***MODIFICATION REQUEST:  
Sydney University Abercrombie  
Precinct Redevelopment  
Cnr Codrington Street and Abercrombie  
Street  
(MP07\_0158 MOD 3)***

- Modification to the Student Accommodation Building

Director-General's  
Environmental Assessment Report  
Section 75W of the  
*Environmental Planning and Assessment Act*  
1979

February 2014

Ground Floor Plan
1:200@A1
11.10.13
4001_DA02-D

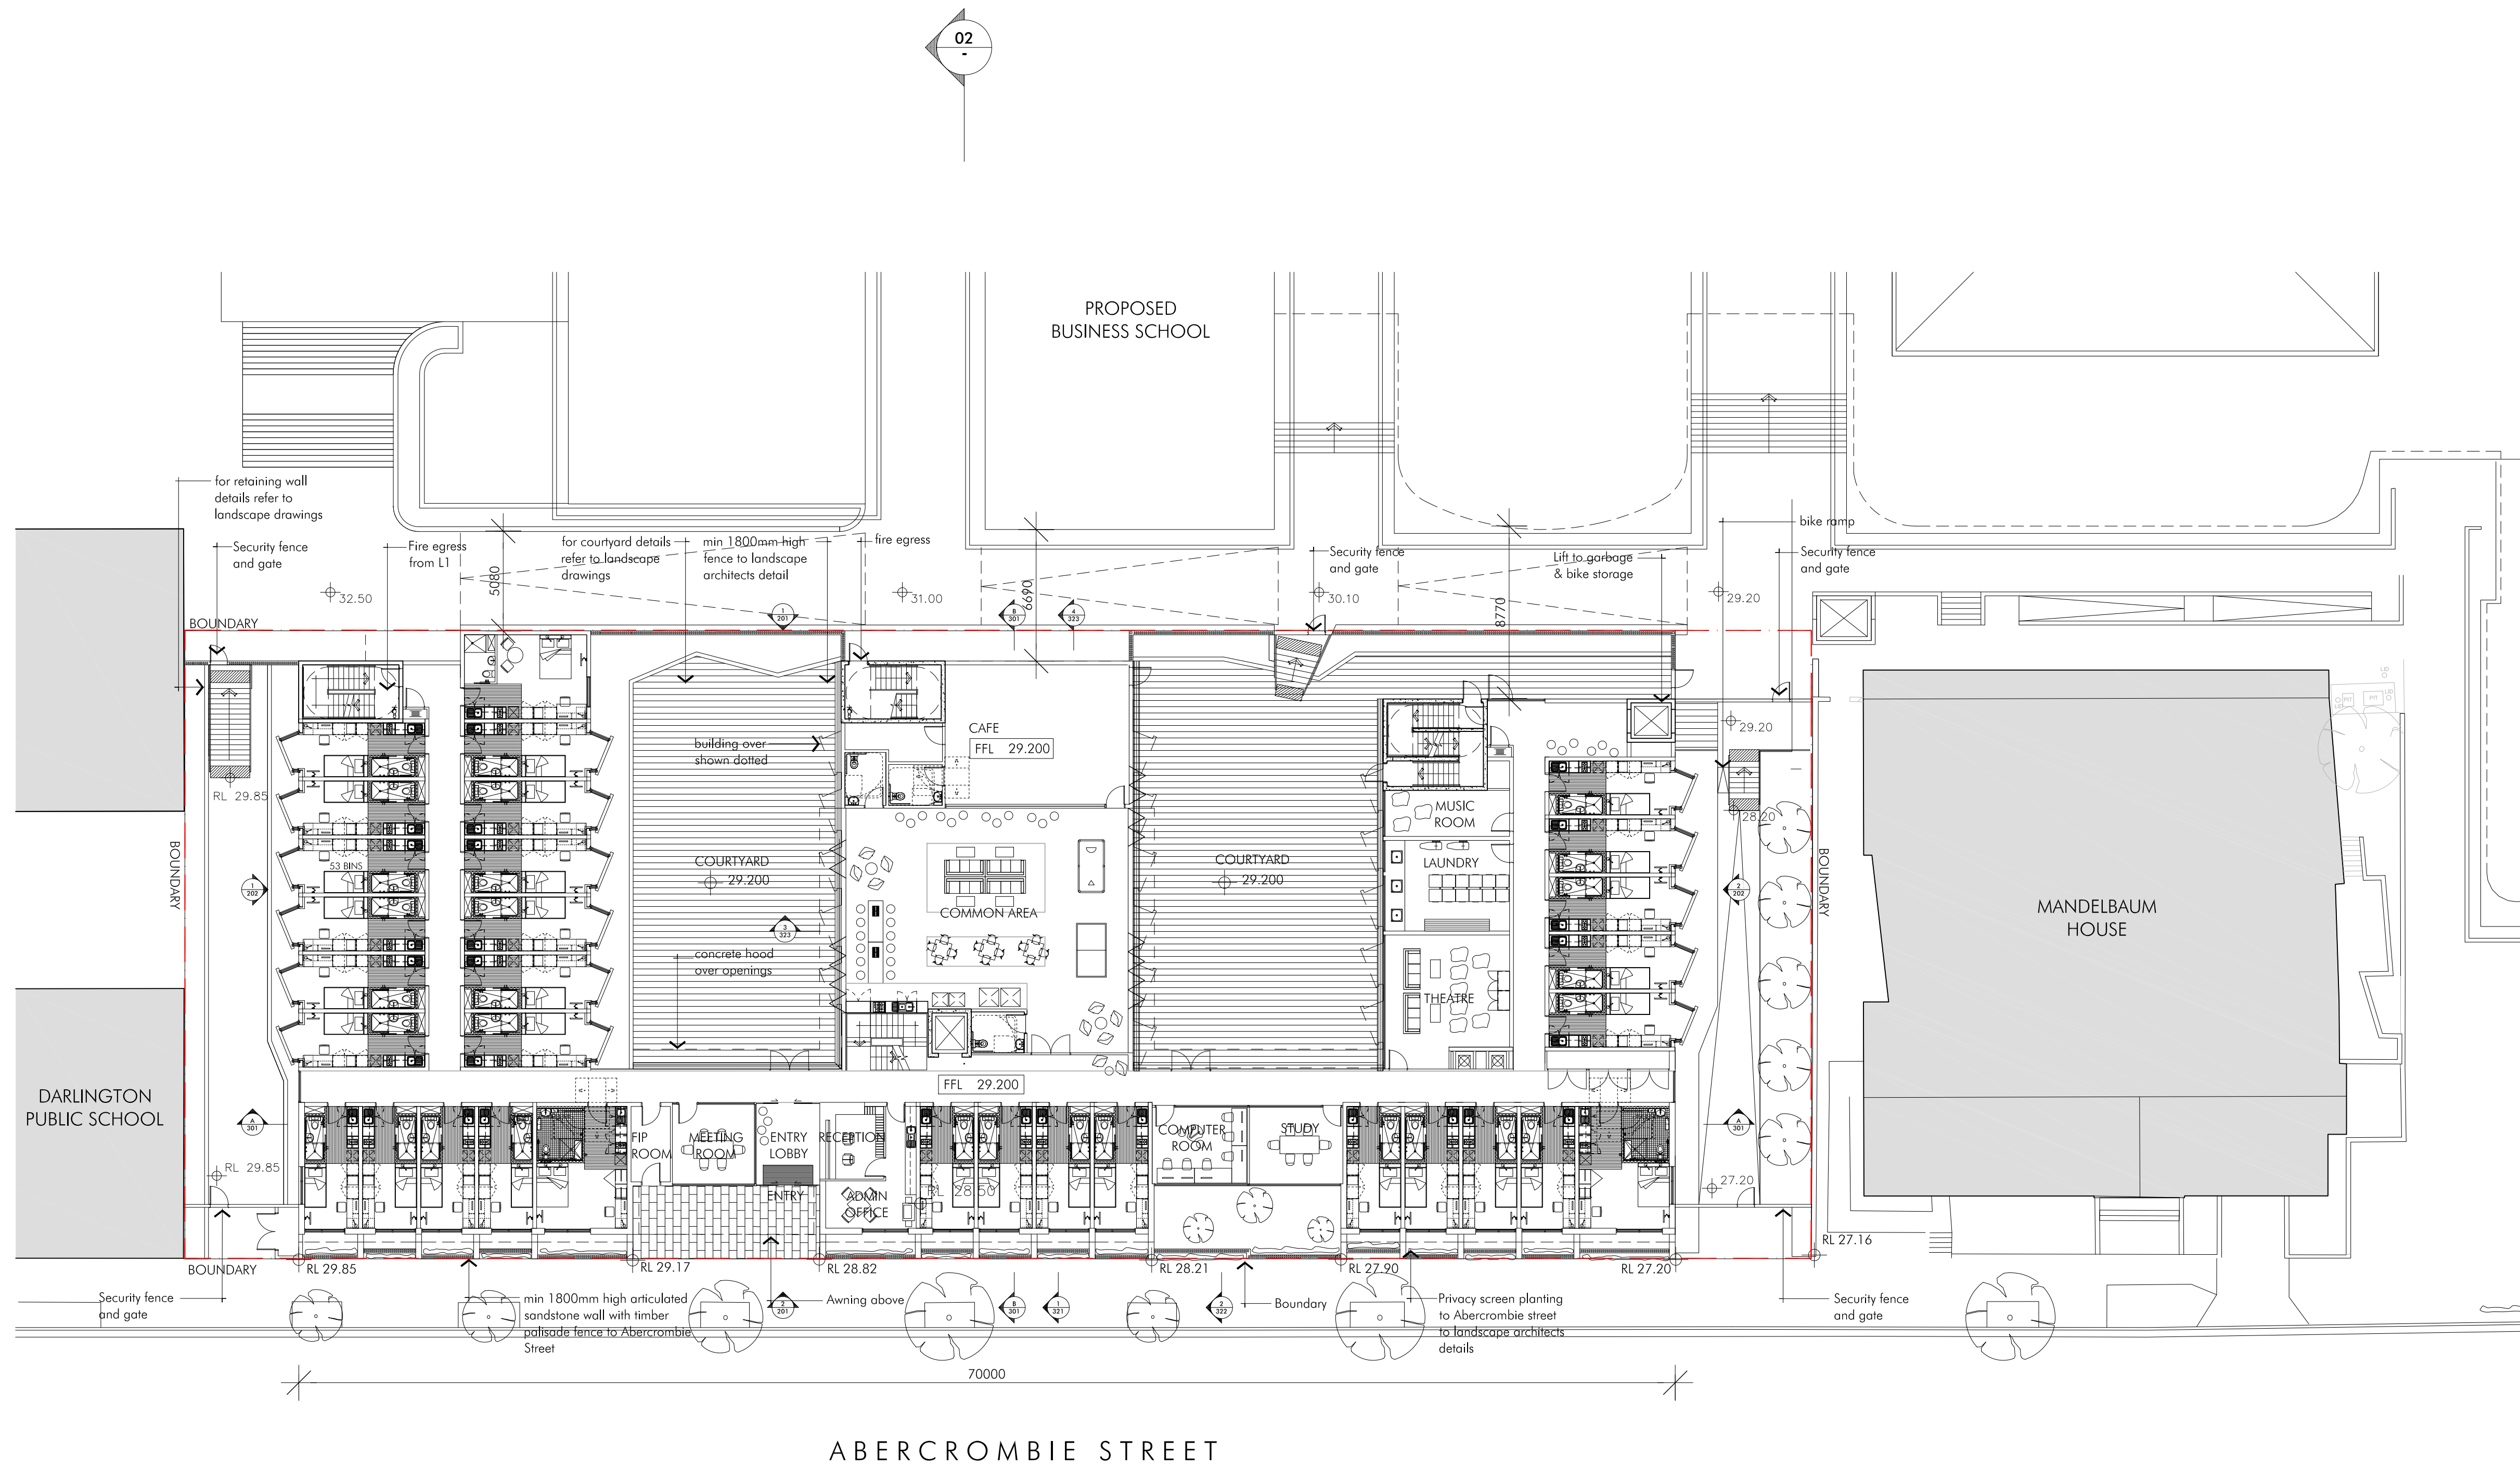
- a minimum floor to ceiling height of 2.7 m should be conditioned;
- the proposed relocation of the café will co-locate compatible uses, though the amenity of the additional student room in the eastern wing is questioned due to its proximity to the laundry, music room and theatre room;

The removal of the Abercrombie Street basement entrance has enabled the eastern edge of the ground floor to be extended east, which in conjunction with other internal layout amendments, makes provision for an additional 12 beds, increasing the total capacity of the college from 188 to 200 beds.

Council advised that it supports the proposed 3.5 m floor to ceiling height of the ground floor, but also requested that a new condition be imposed requiring that a minimum 2.7 m floor to ceiling height is achieved for all habitable areas within the building. The department considers the imposition of this new condition is appropriate as it will ensure a reasonable level of amenity is achieved for future occupants.

02 ELEVATION SOUTH (ABERCROMBIE STREET)
SCALE 1:200

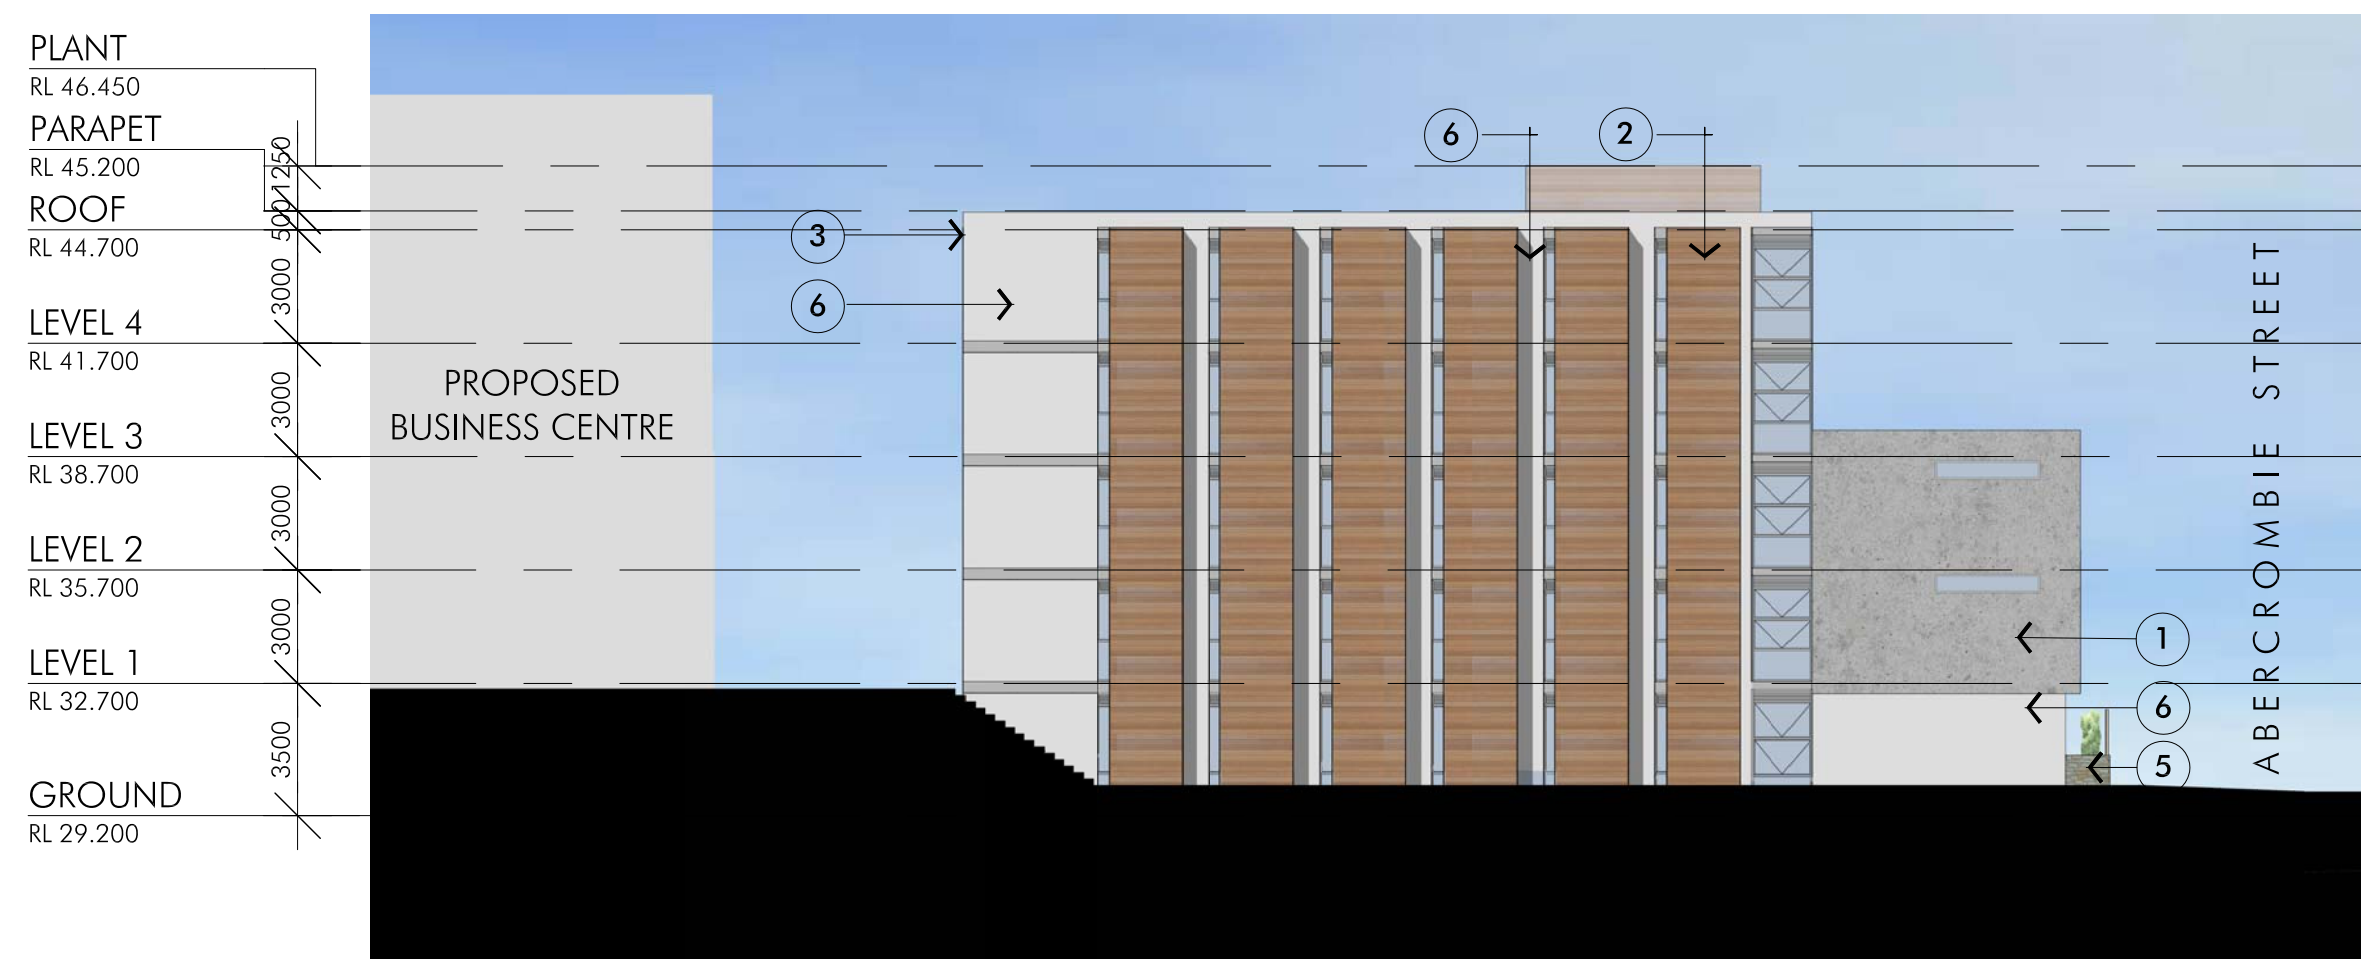
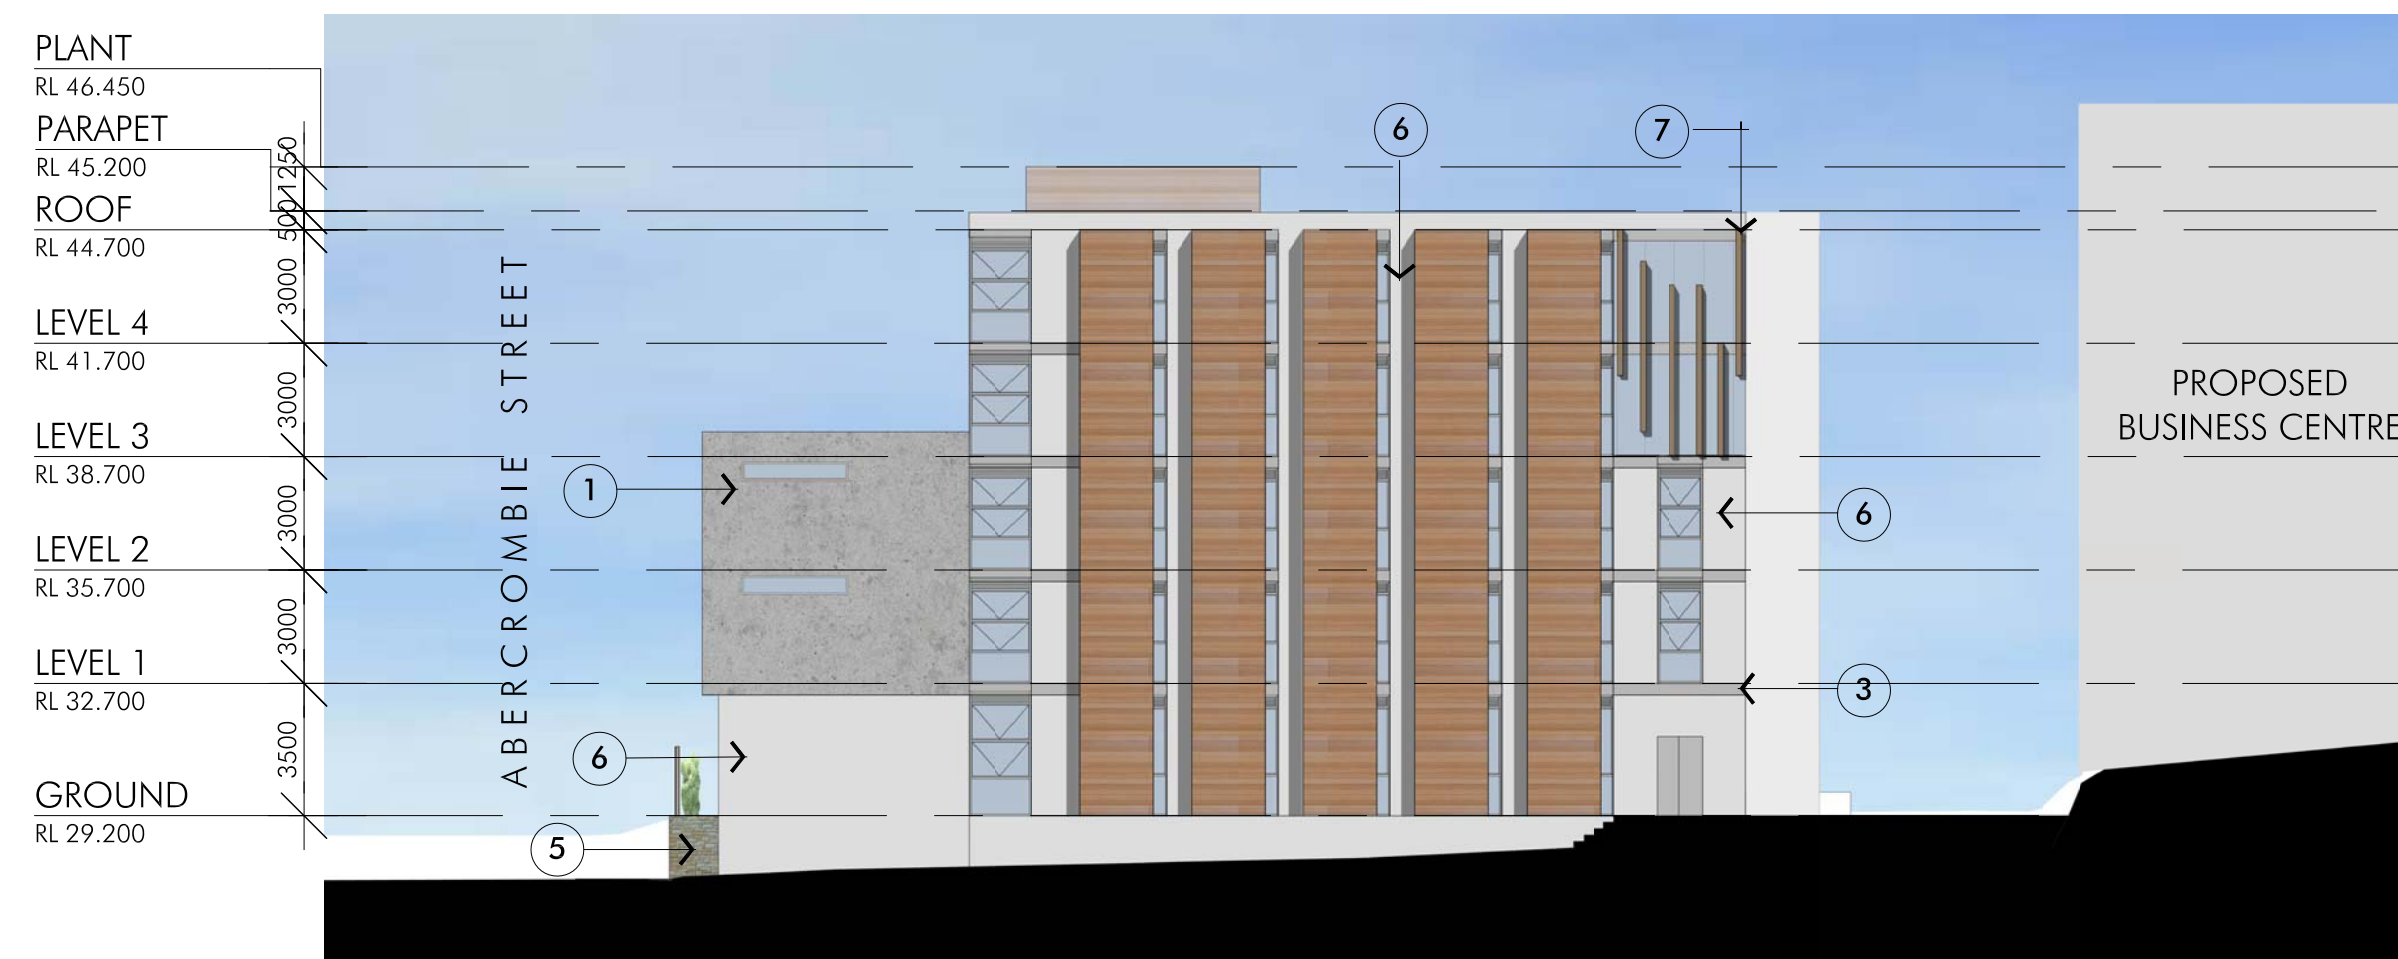
- council's specialist Urban Designer and Senior Heritage specialist are generally supportive of the proposed amendments, specifically the façade articulation and materiality;
- building and design features exacerbate the inconsistency in the building setback from Abercrombie Street with Mandelbaum House;
- the design of the lower scale frontage to Abercrombie Street better echoes the forms and proportions of the terraces opposite and is no longer 'institutional';
- a more careful selection of materials is required for the external ground floor wall and retaining wall due to their visual prominence;

Council further noted that the lower front portions of the eastern and western elevations of the student accommodation building should be clad in a more suitable material, such as sandstone rather than the exposed concrete finish (labelled '6' on **Figures 8 and 9**). In response, the proponent advised that the use of the concrete panelling along these elevations was selected to provide a contemporary design response to the extensive use of sandstone materials on heritage buildings throughout the University's campus.

The department considers that the treatment of the lower portions of the western and eastern elevations provides a satisfactory design response to the setting, noting that the proponent proposes the use of sandstone within the design of the proposed front fencing for the college. It is also noted that these areas are adjacent to proposed pedestrian pathways, which will be landscaped on both sides (see **Figure 11**). This will assist in softening the contemporary concrete finish of these elements of the building.
